PLAN REVIEW SHEET

Petition #: RZP 2022-082

Address: 815 Mallard Creek Rd.

Request: UR-2 (CD)

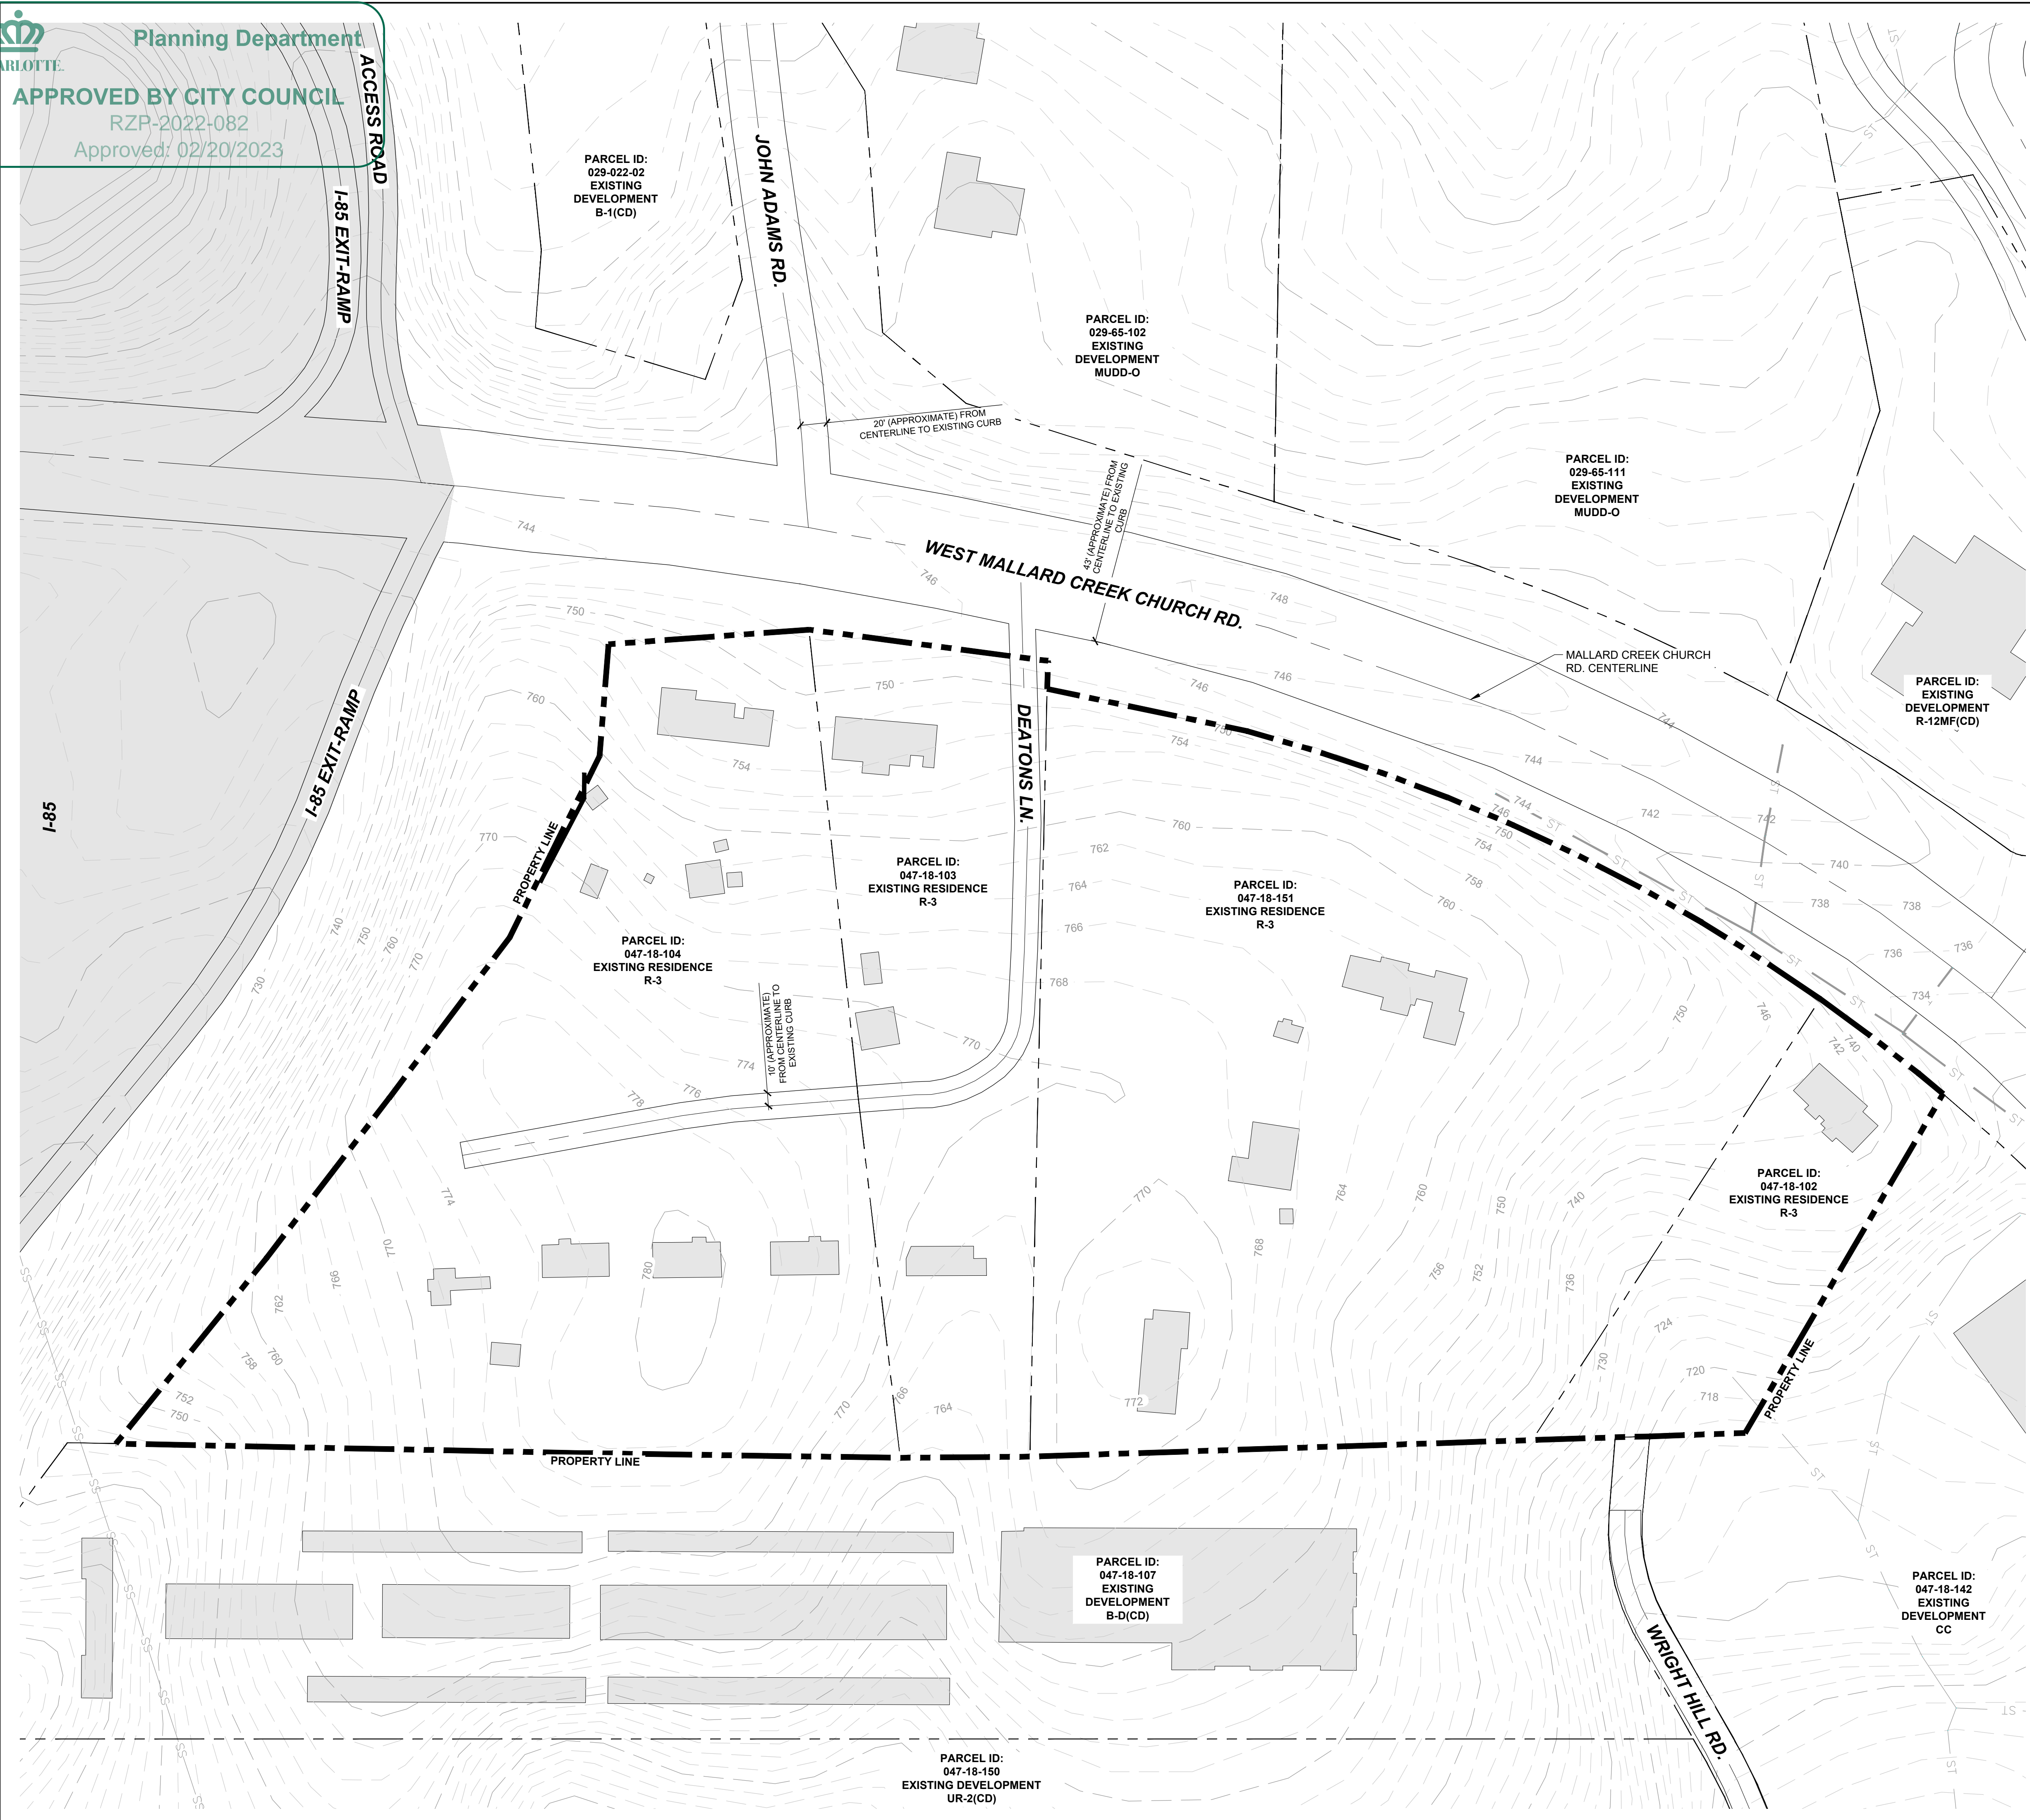
The site is located on CATS local bus routes #47x and #59 along Mallard Creek Road. The existing bus stop at Pinnacle Drive will be relocated to frontage opposite Mallard Glen Drive. CATS requests the construction of ADA compliant bus stop type 60.02A. The final location will be determined during the Land Development plan review process.
